Town & Country Planning Act 1990 (as amended)
Town and Country Planning (Development Management
Procedure) (England) Order 2015
Application for Planning Permission
DECISION NOTICE

Application Ref: A/31/19/PL

Land between Ashurst & Badgers
 Ham Manor Way

1 No. two storey house (resubmission following A/87/18/PL). This application is a Departure from the Development Plan & affects a Public Right of Way.

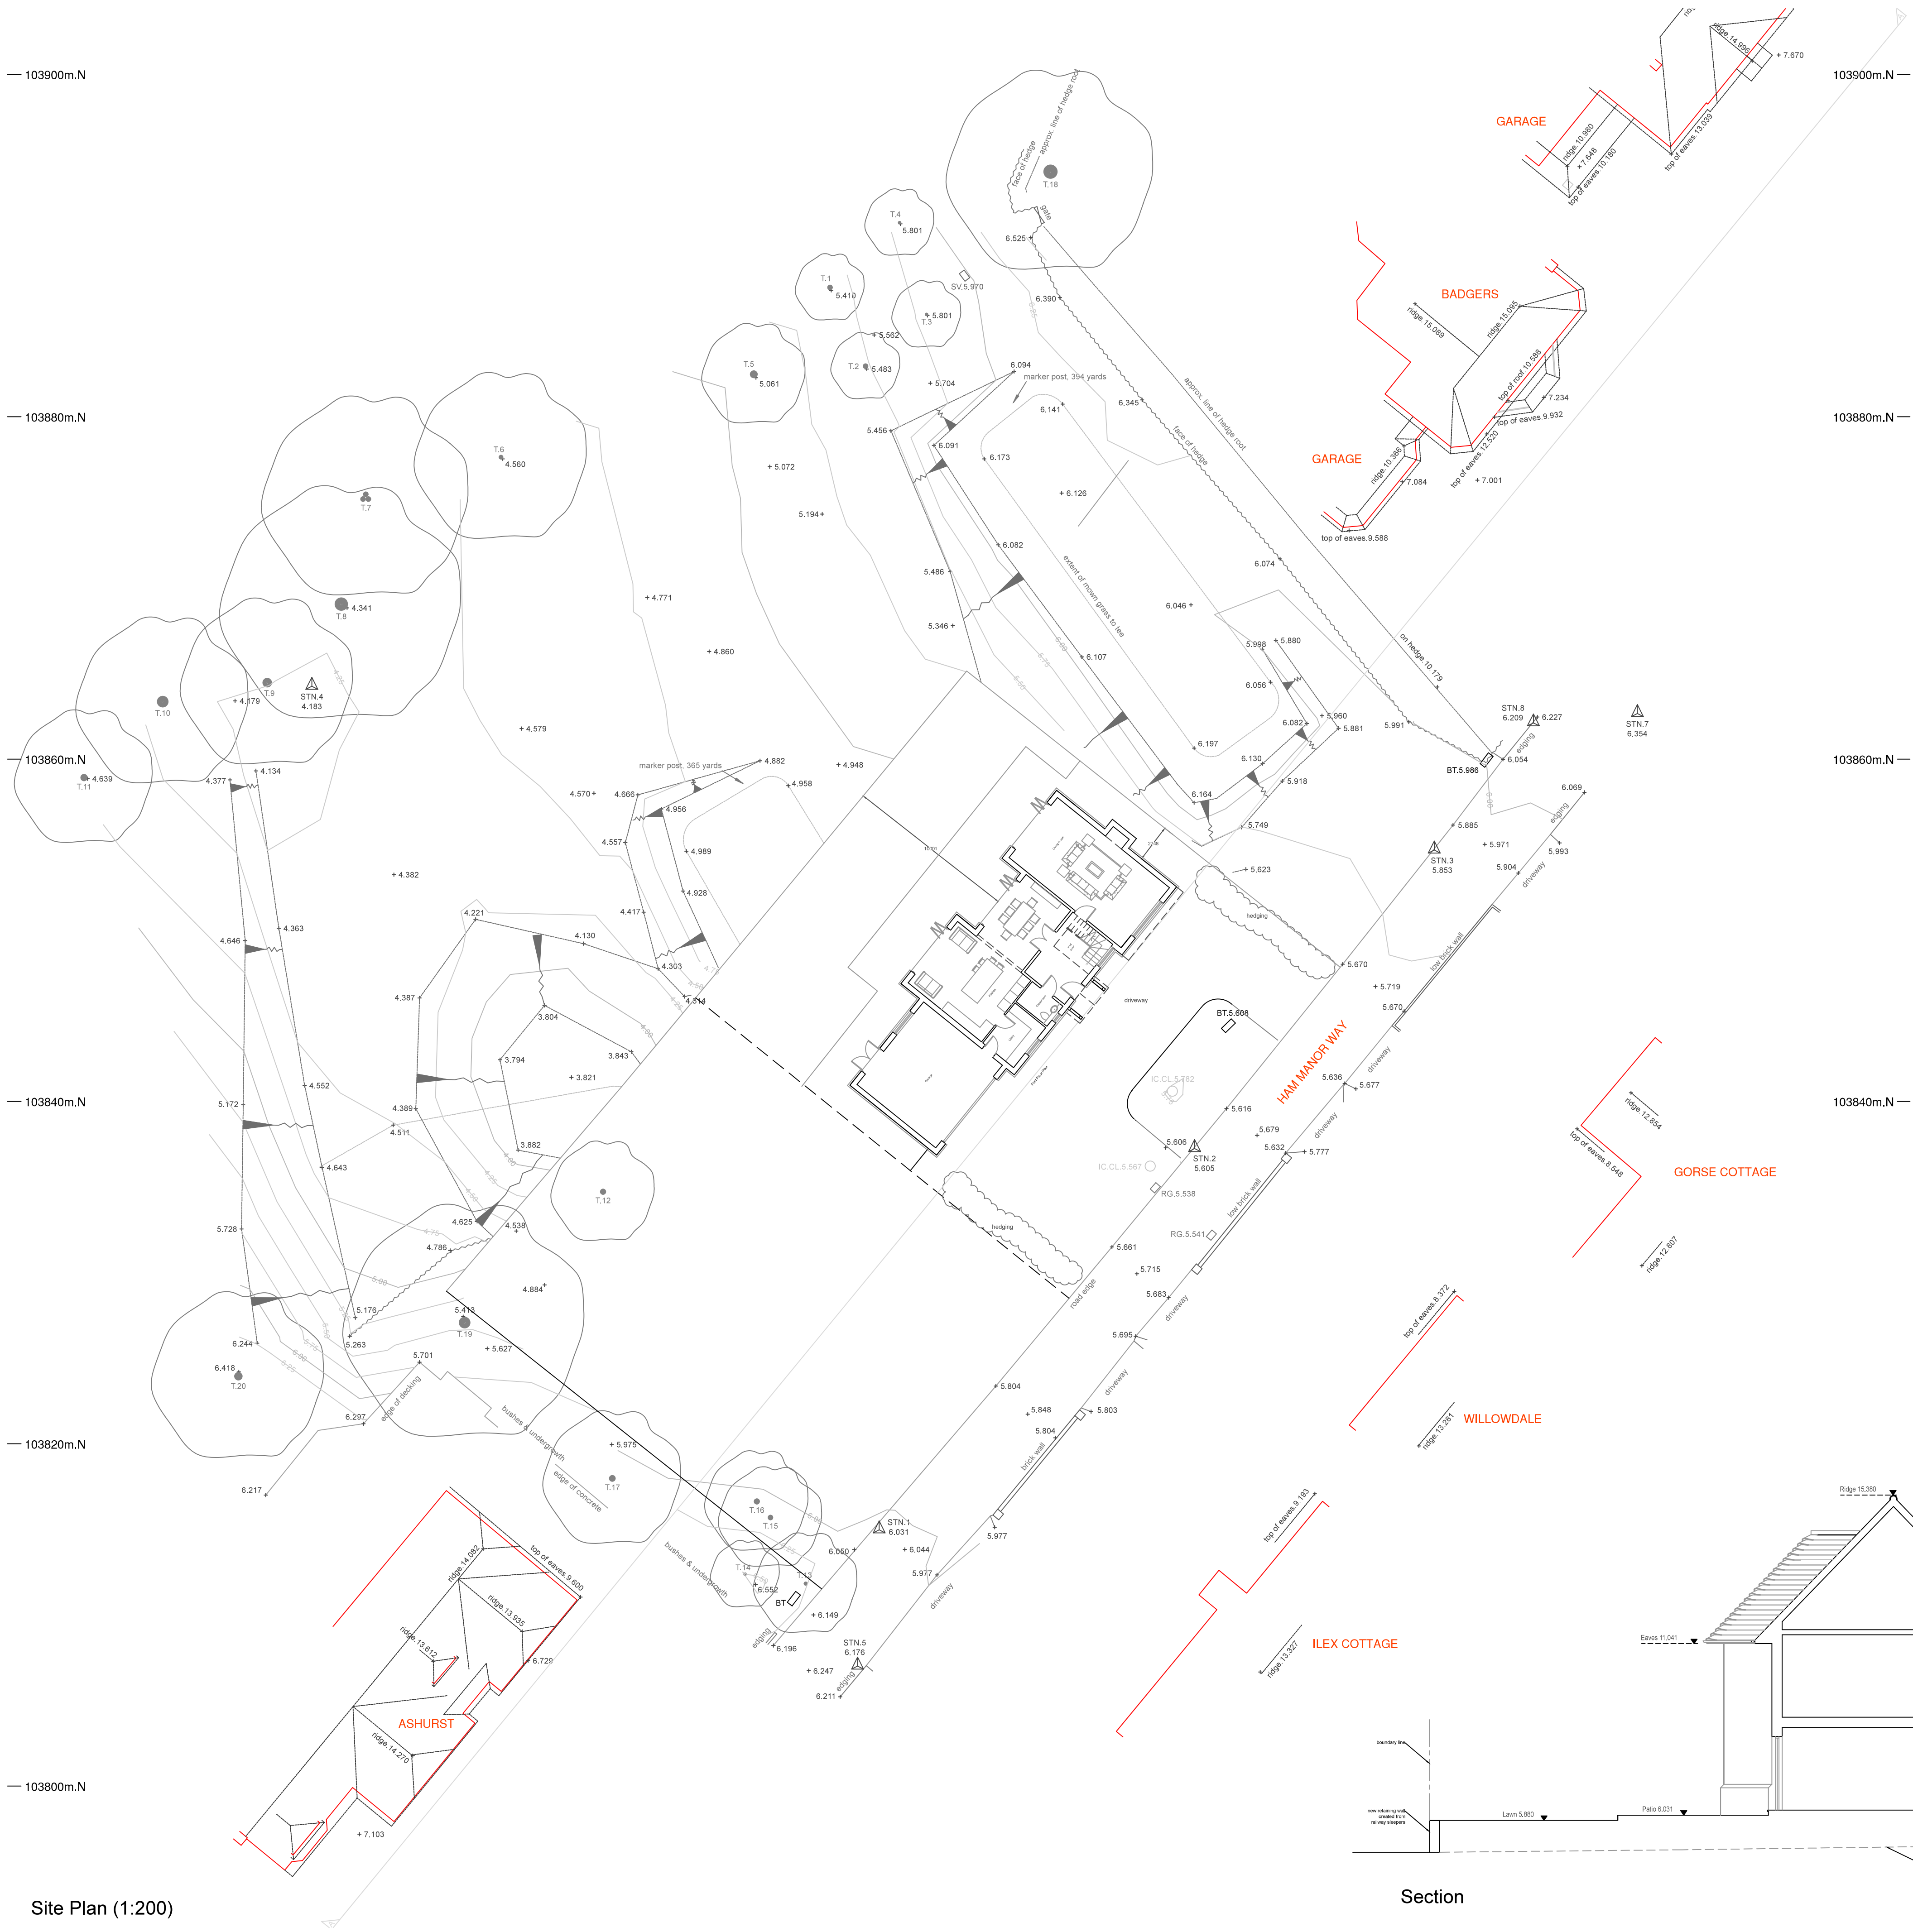
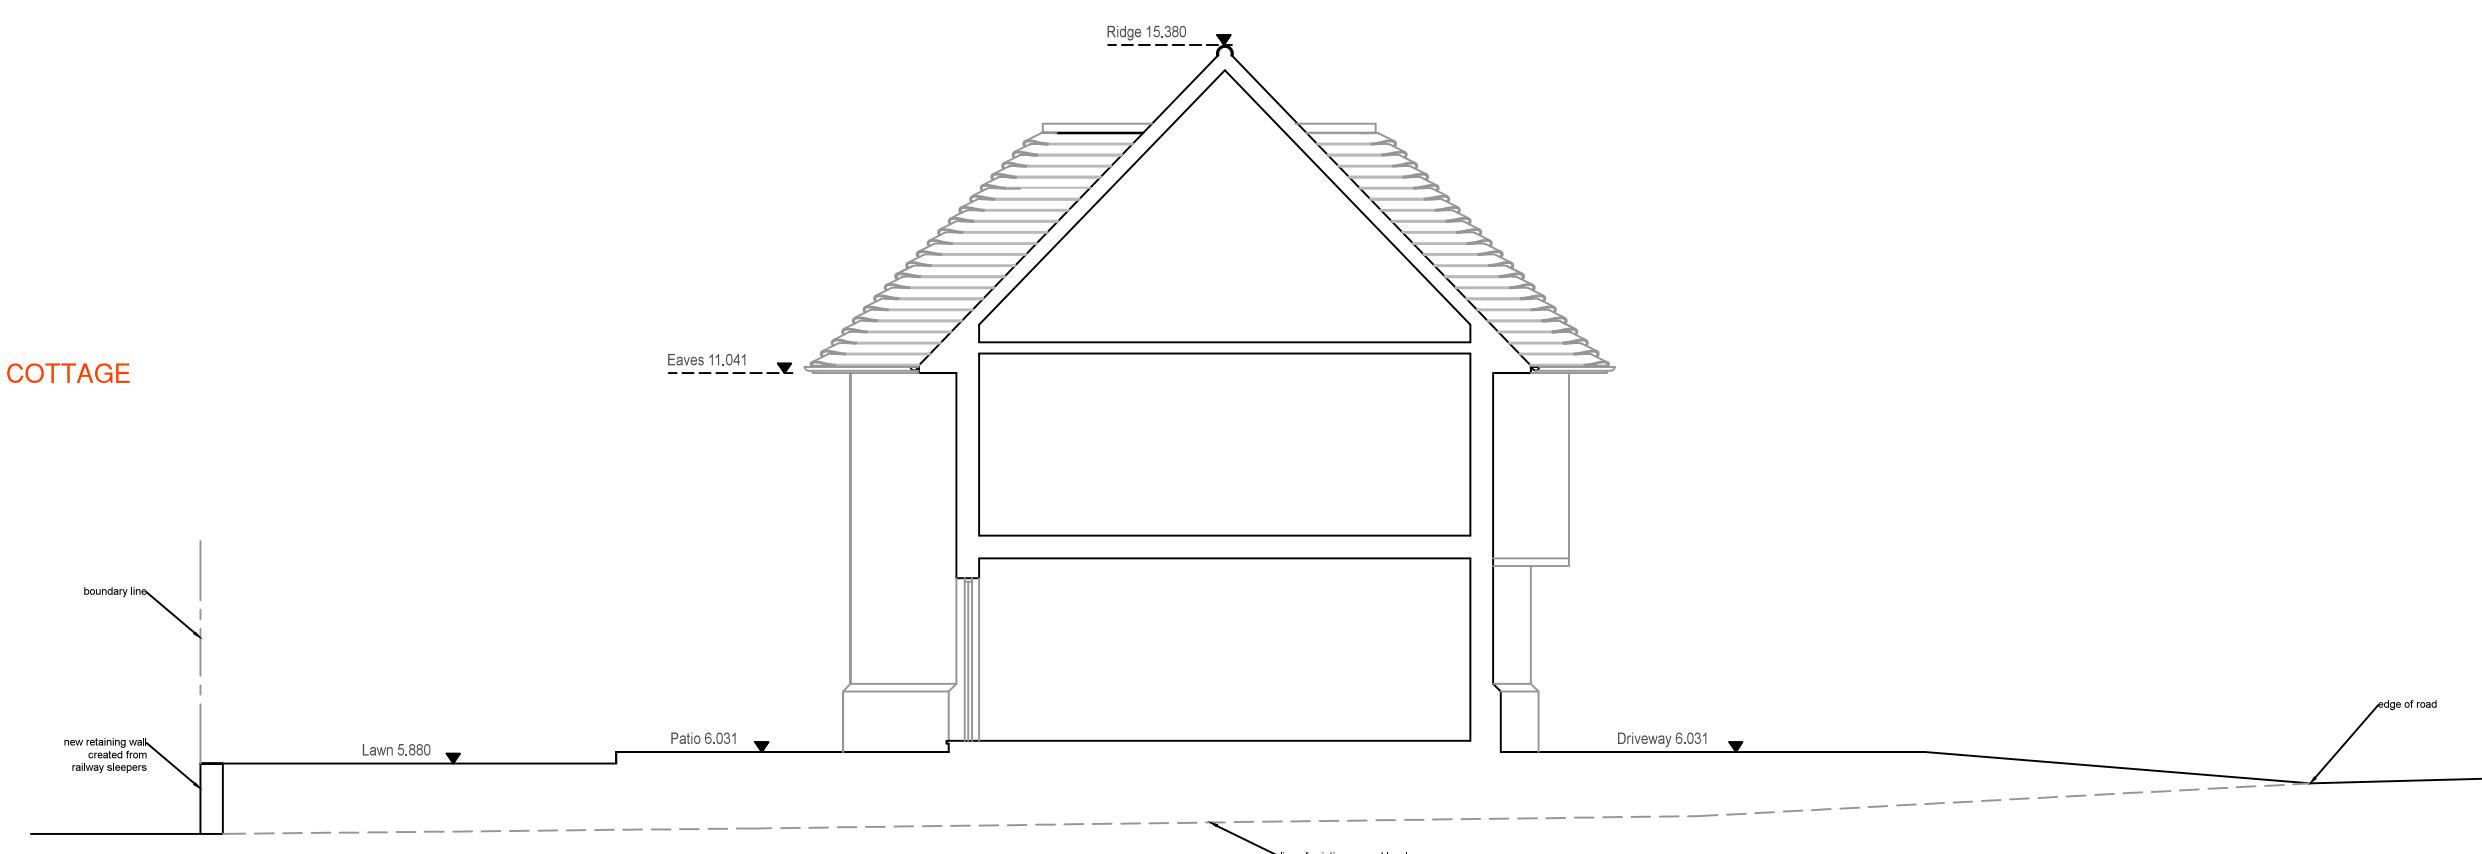
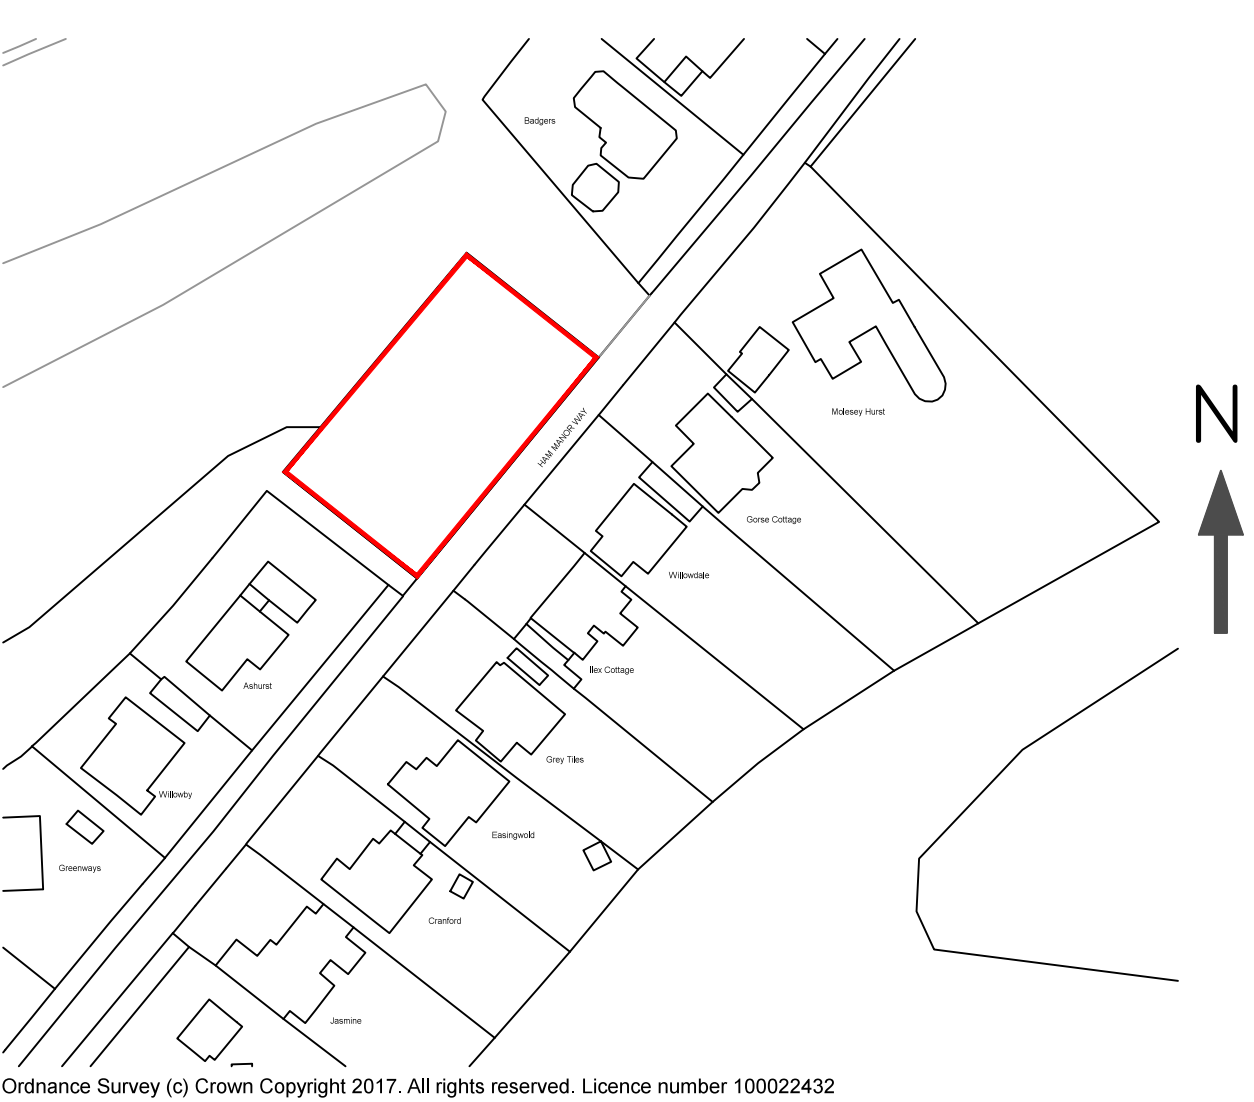
- 1 Given the position of the dwelling within the established golf course which is outside the built up area boundary and designated as a Local Green Space in the Angmering Neighbourhood Development Plan the increase in width of the site closer to neighbouring side boundaries would represent an unacceptable incursion into the area and would constitute a prominent form of development which would adversely affect the character and appearance of the area in conflict with policies CSP1, DDM1 and OSR DM1 of the Arun Local Plan and policies HD5 and CLW2 of the Angmering Neighbourhood Plan.
